TO: Brad Bingham DATE: 6/25/10
COA Hydrology. CC: _____
FAX #: 924-3864
FROM: Åsa Nilsson-Weber, Isaacson & Arfman, P.A.
REFERENCE: Black Arroyo Park A12/D16C1
Revised drain basin
TOTAL NUMBER OF PAGES (INCLUDING COVER) 2

BLACK ARROYO PARK
REVISED DRAIN BASIN
JUNE 25, 2010

BLACK ARROYO PARK IMPROVEMENTS
STORM DRAIN PLAN

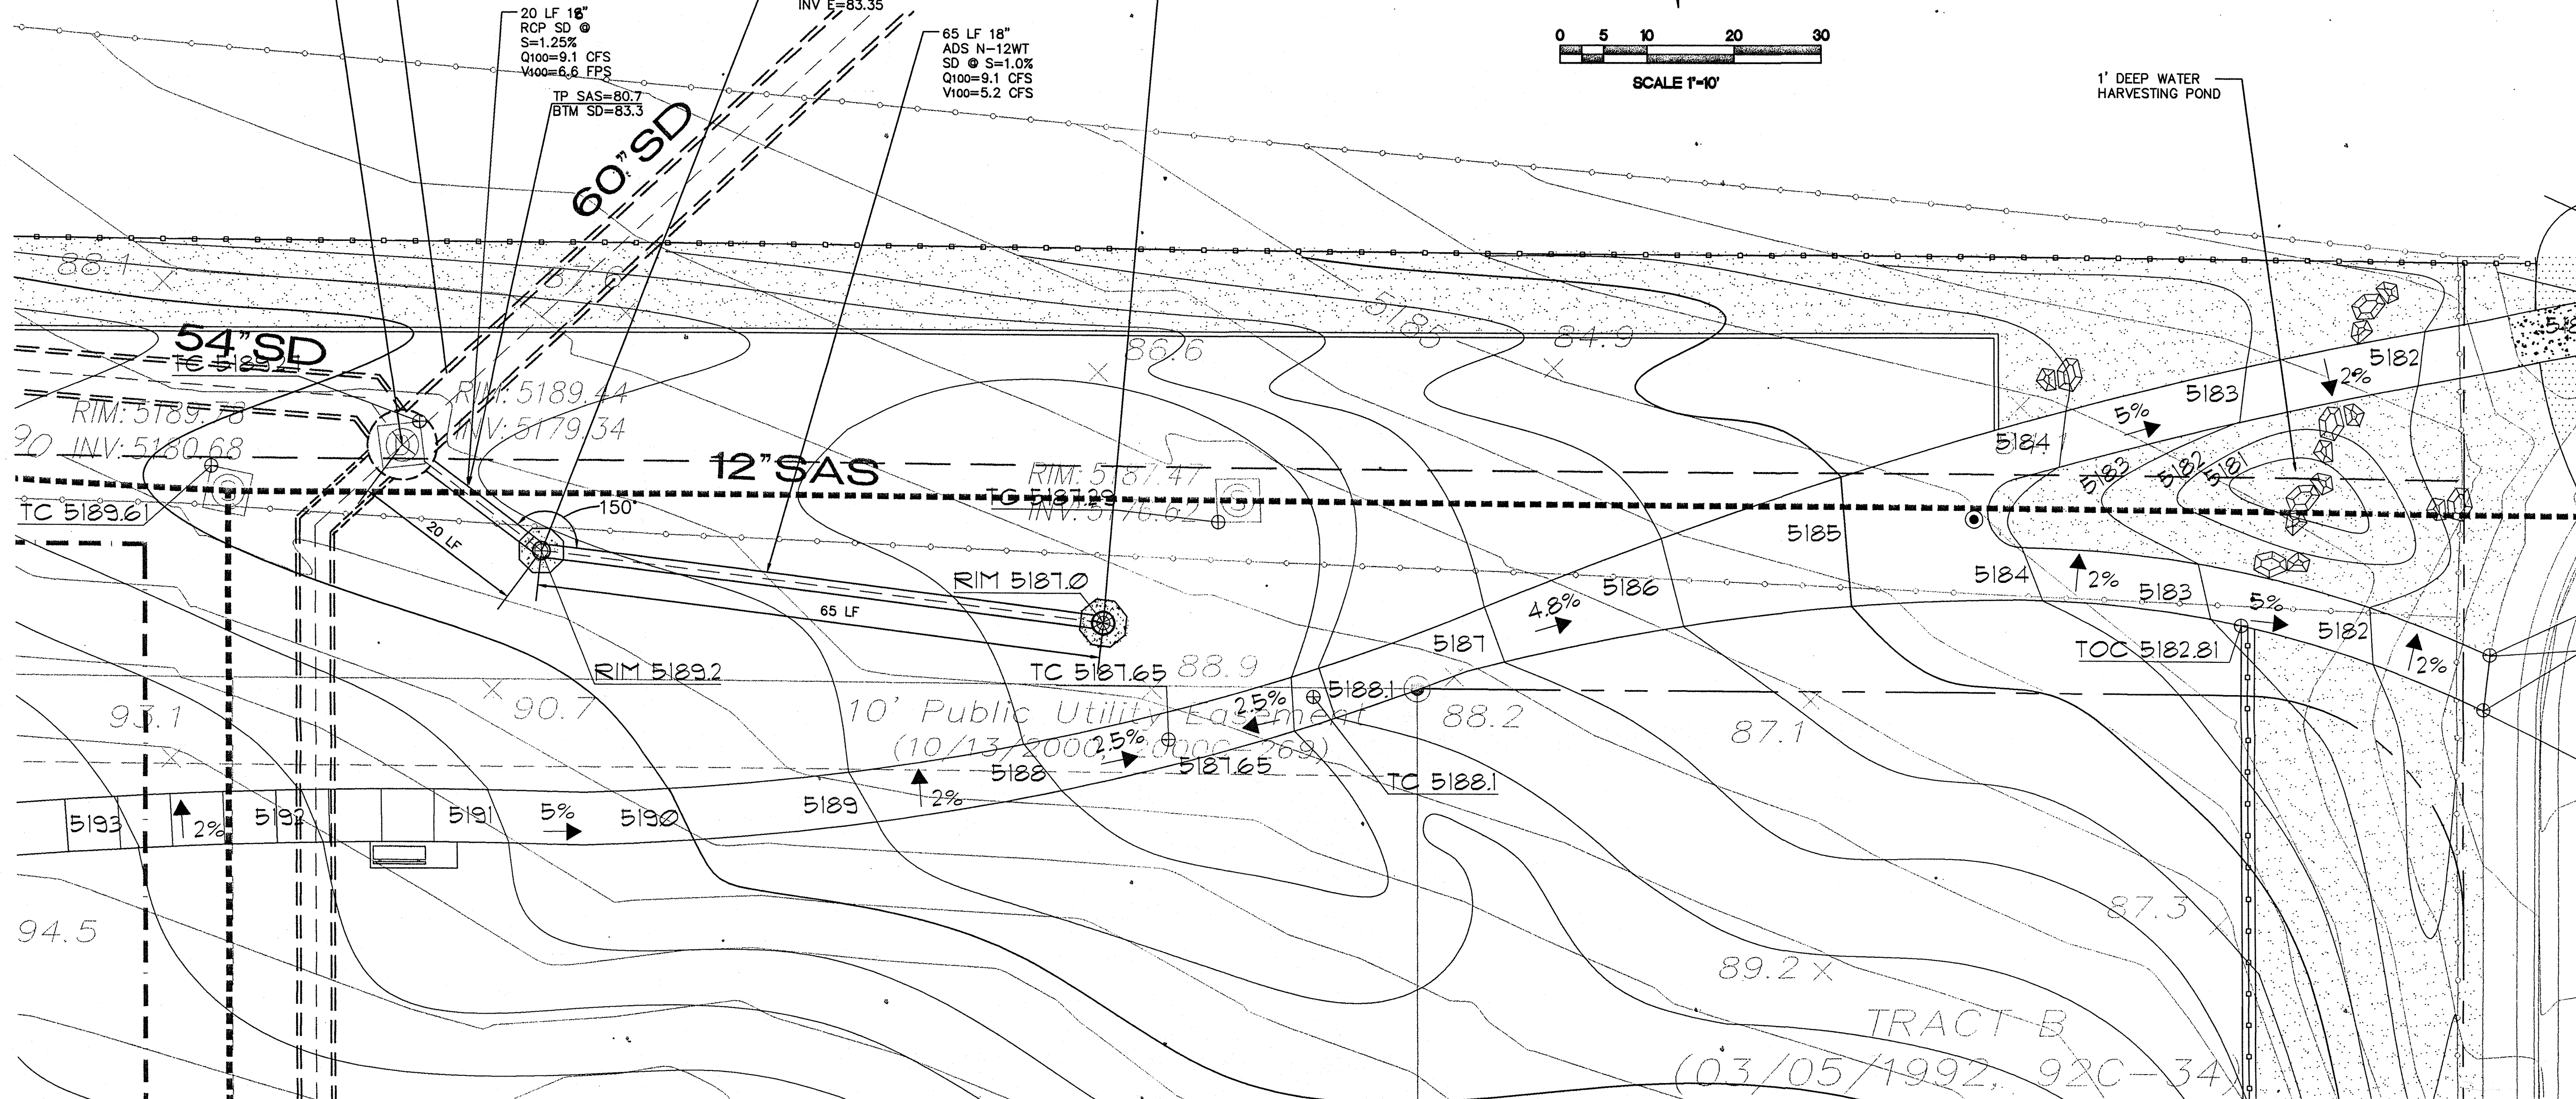
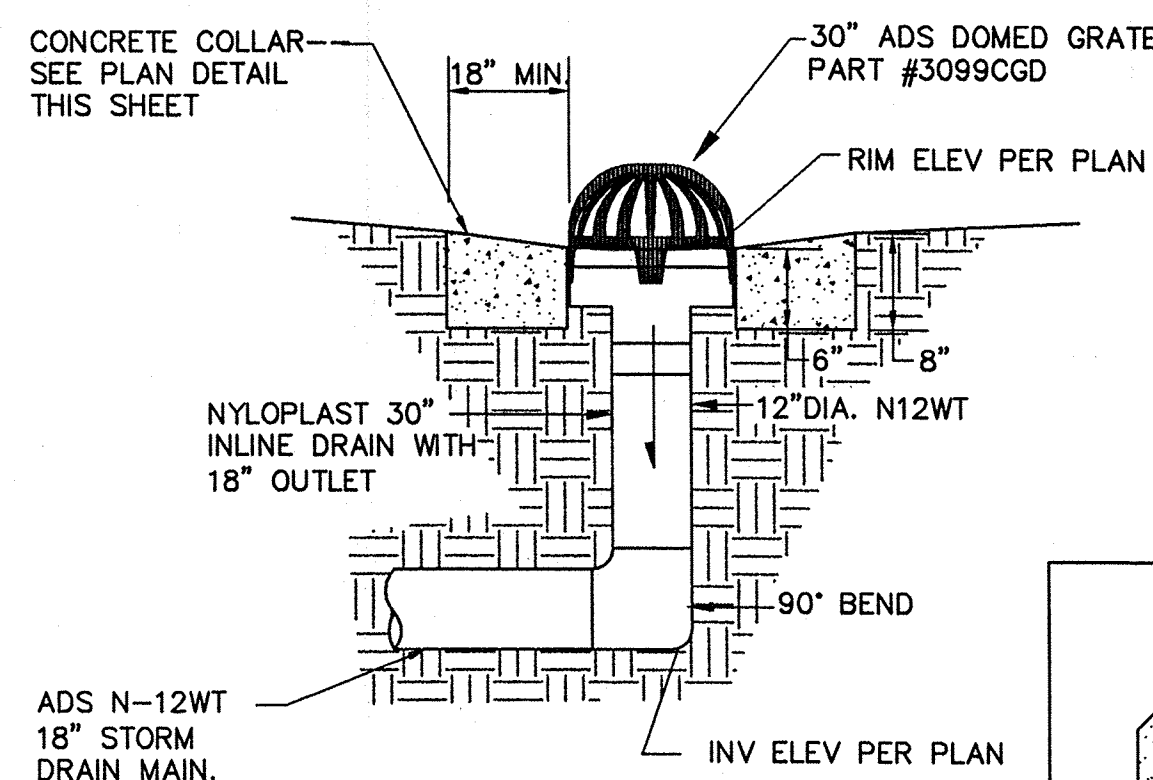
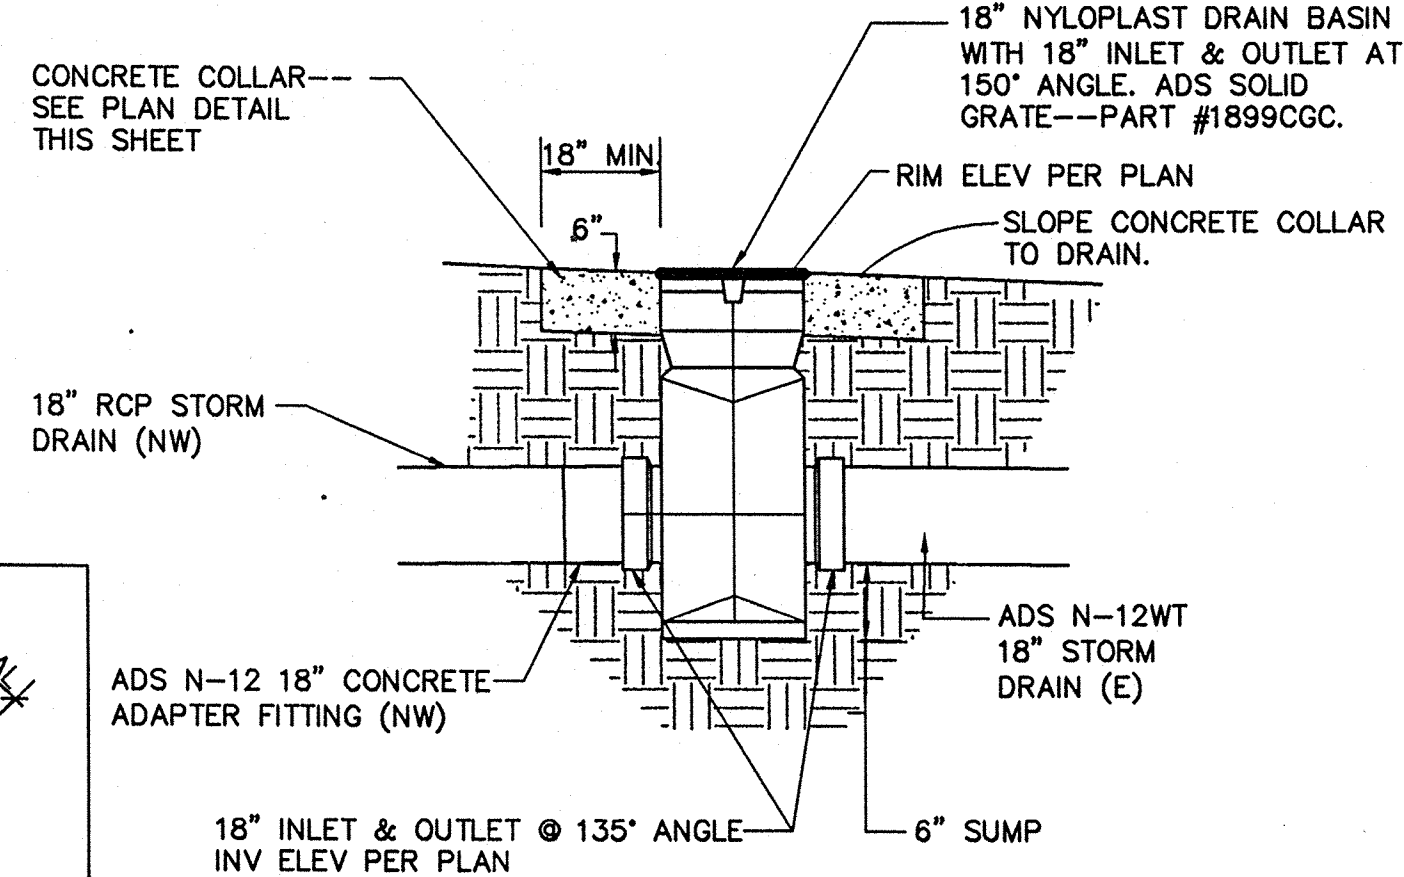
Here is the detail of the
concrete basin replacing the
ADS inline drain - for your approval
Thank you.

REVISION NOTE 6/25/10:
1-30" INLINE DRAIN REPLACED
WITH 30" DIA. CONCRETE BASIN
PER DETAIL THIS SHEET.

OK

Approved
